Version 1 comments
 unresolved. Please resolve:

Patio Cover
 8310 Lodge Grass Way
 Colorado Springs, CO 80908
 Gene Roschewski

Patio Cover Lodge Grass way

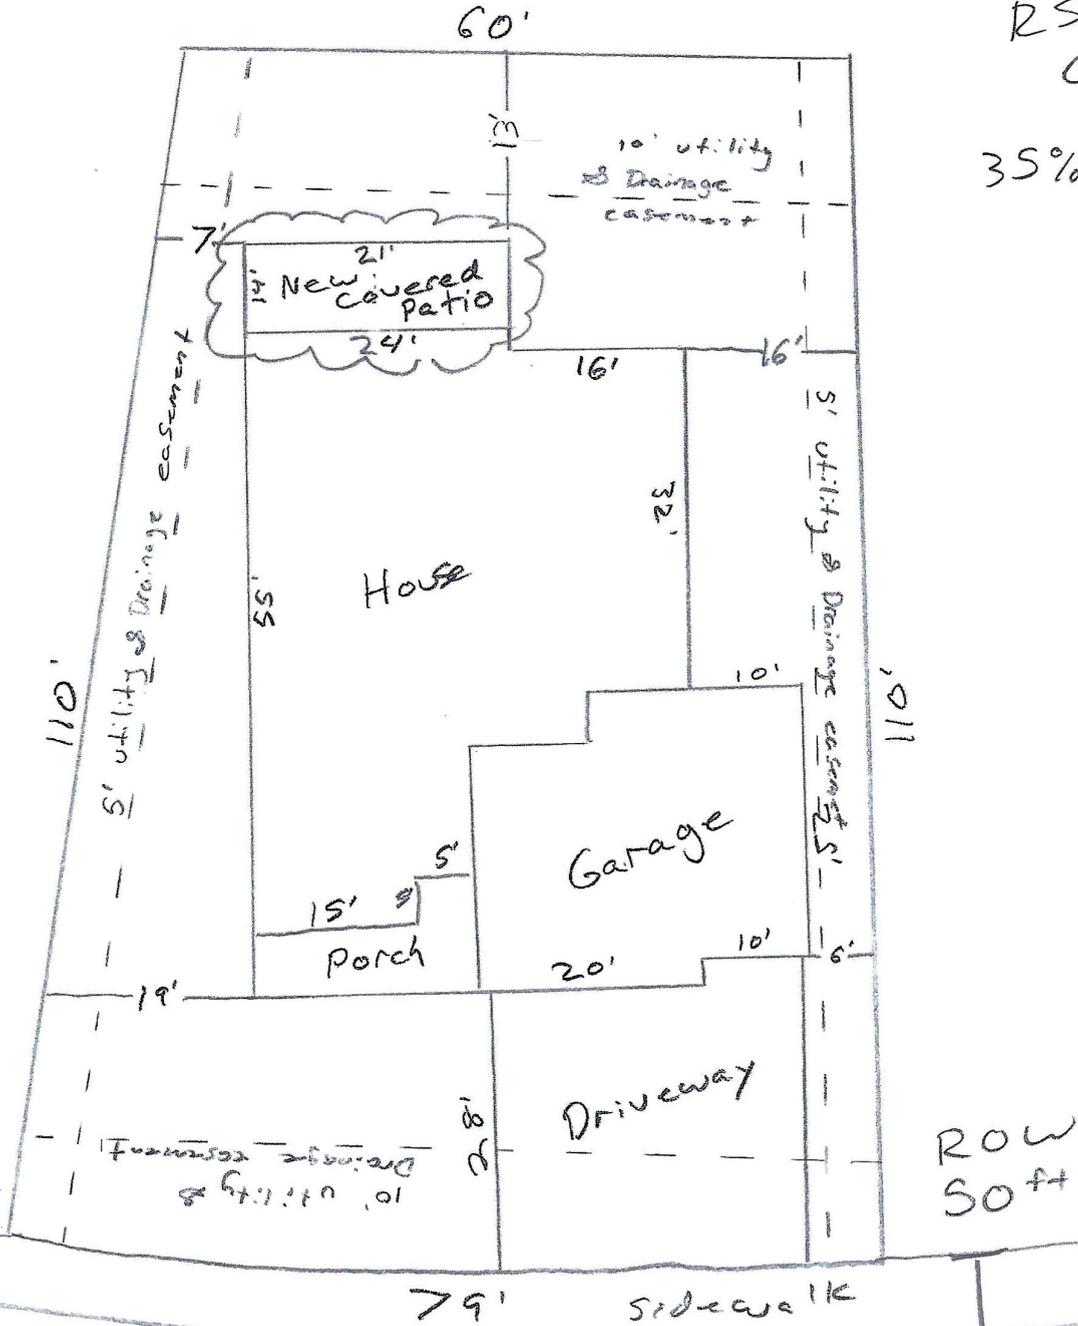
- Date, north arrow, and a graphic scale
- Location of the property lines, right-of-way,
- Dimensions of all property lines, rights-of-way,
- Location of existing and proposed water and wastewater infrastructure, including well(s) and septic system(s)
- Location of all no-build areas, floodplain(s), and drainage facilities
- Existing/proposed land use, parcel size, and zoning
- Percent of open space, landscaping, and lot coverage
